EPC STORMWATER REVIEW COMMENTS
 IN ORANGE BOXES WITH BLACK TEXT

2023 Financial Assurance Estimate Form
 (with pre-plat construction)

PCD File No.
 PPR-2318

PROJECT INFORMATION		
Paint Brush Hills Pumpouse 6 Site Development Plan	5/3/2023	
Project Name	Date	PCD File No.

DRAWN BY:	DESIGNED BY:
JS	JS/RG
JOB NUMBER:	1070.0026
DATE:	9/12/23
SCALE:	1" = 20'
DRAWING DESCRIPTION:	GEC PLAN
SHEET NO.:	3 of 5

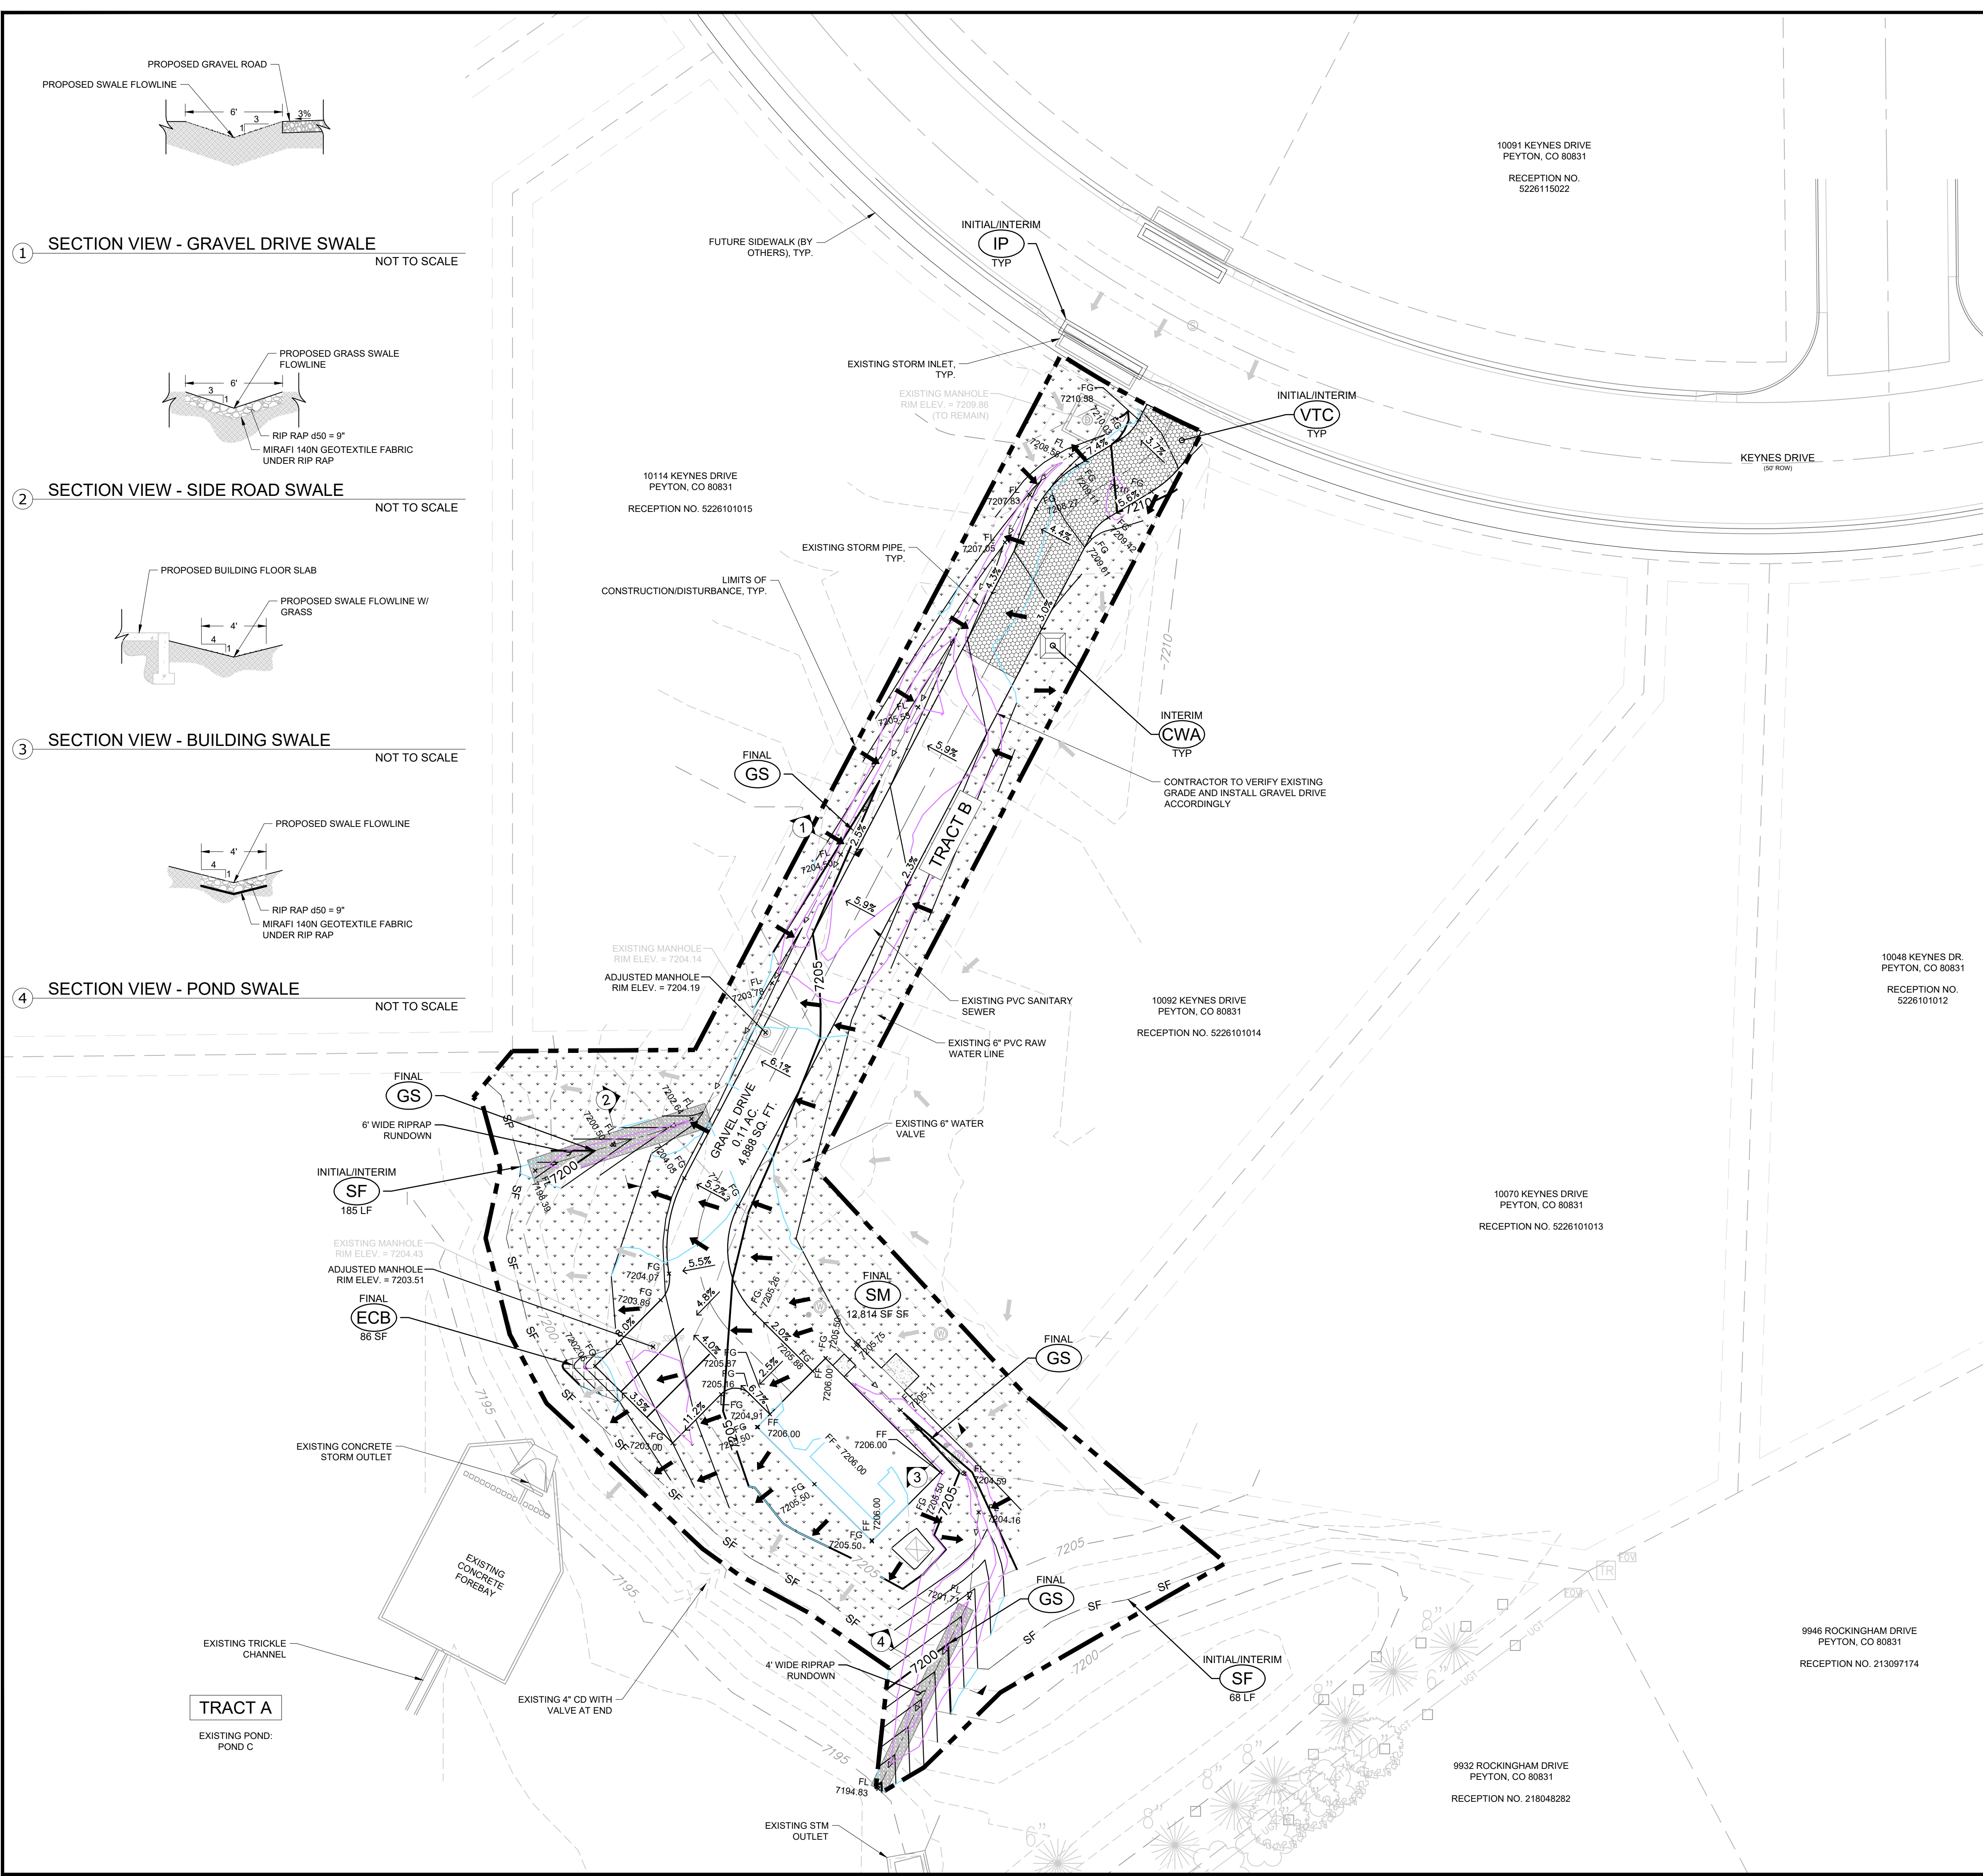
Show on GEC Plan
